Objection Submission to An Coimisiún Pleanála

Re: Planning permission for the construction of Tirawley Windfarm consisting of 16 no. wind turbines, a permanent 110kV substation, an energy storage system in the form of a battery array located within container units, 110kV underground cable and grid connection, and ancillary development in the townlands of Ballymurphy, Ballynaleck, Barnhill Lower & Upper, Barroe, Billoos, Carn, Carrickanass, Carrowmore, Castlelacken Demesne, and other townlands in County Mayo.

Case Number: PAX16.324258

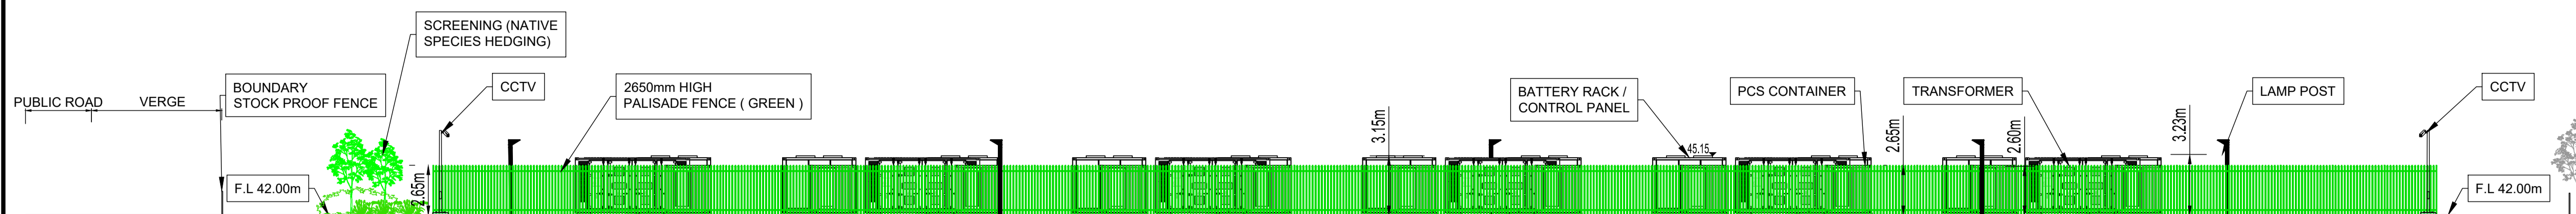
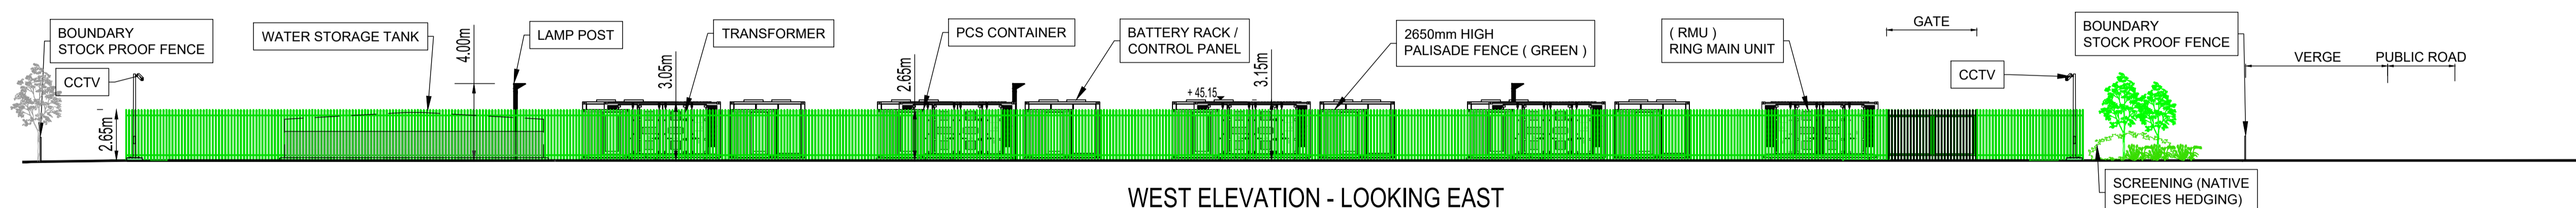
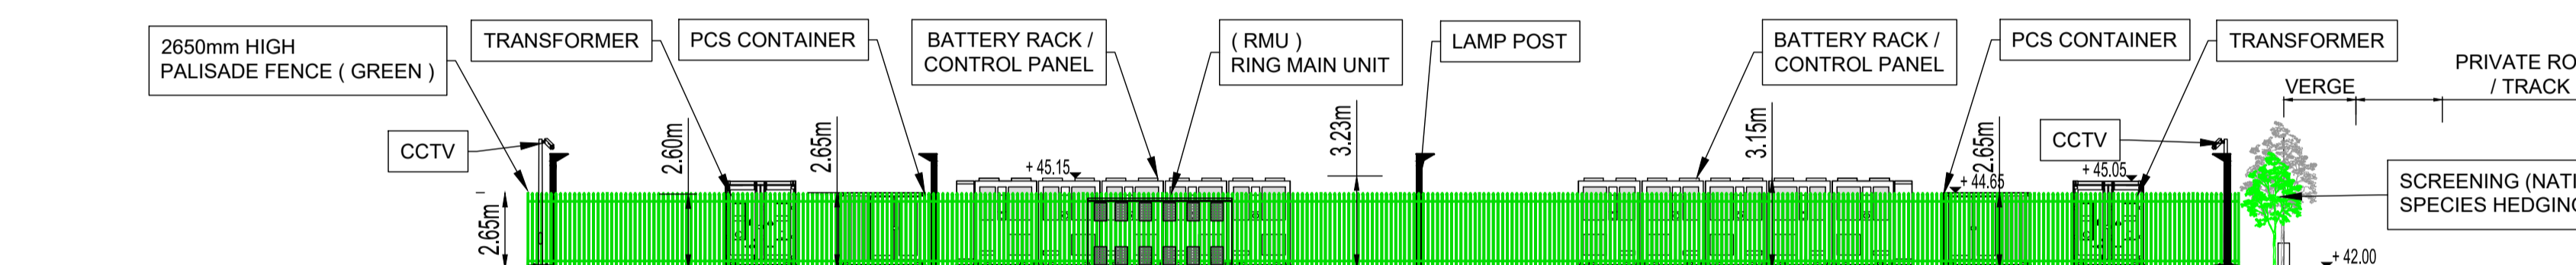
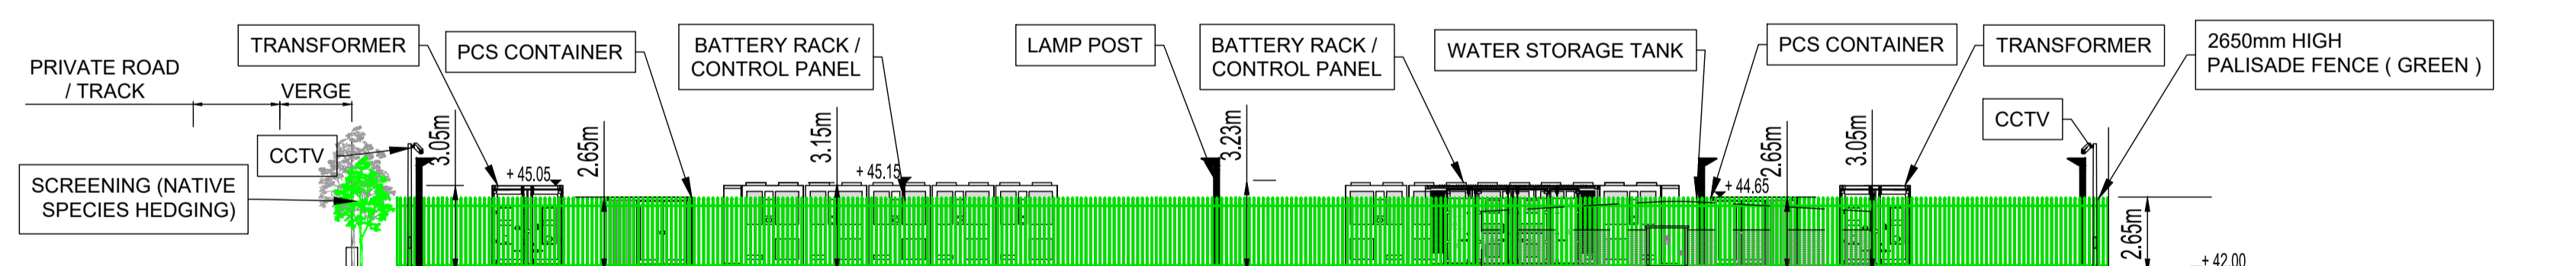
My grazing land lies adjacent (approximately 5m across the road) to and downslope of the proposed BESS location. The natural topography of the site means that any uncontained firewater will flow directly towards my land in Carrickanass. If this contaminated water reaches my grazing land, the grass consumed daily by my cattle will be contaminated with heavy metals and toxic chemicals.

- Total fire-water containment capacity (bundling) sufficient to retain 110% of maximum fire-suppression water volume.
- Zero discharge capability to any surface water or adjacent agricultural land
- A contaminated water removal and disposal protocol.
- Any assessment of the impact of fire-water run-off on adjacent agricultural enterprises

In the absence of such demonstration, the BESS must be relocated to a position where topography and engineered containment prevent any possibility of run-off reaching my productive farmland.

My grazing land lies to the east/northeast of the proposed BESS. The prevailing wind direction at this exposed Atlantic coastal site is westerly/south-westerly. This means that toxic airborne deposits from a BESS fire would be carried directly onto my fields, contaminating grass that my livestock consume and my home.

I submit that the applicant must be required to provide atmospheric dispersion modelling for a worst case thermal runaway scenario, demonstrating the deposition zone for toxic particulates and gases. The BESS must be sited such that no productive agricultural land falls within the modelled contamination zone under prevailing wind conditions. I have included the below references in relation to thermal runaway and BESS fires.
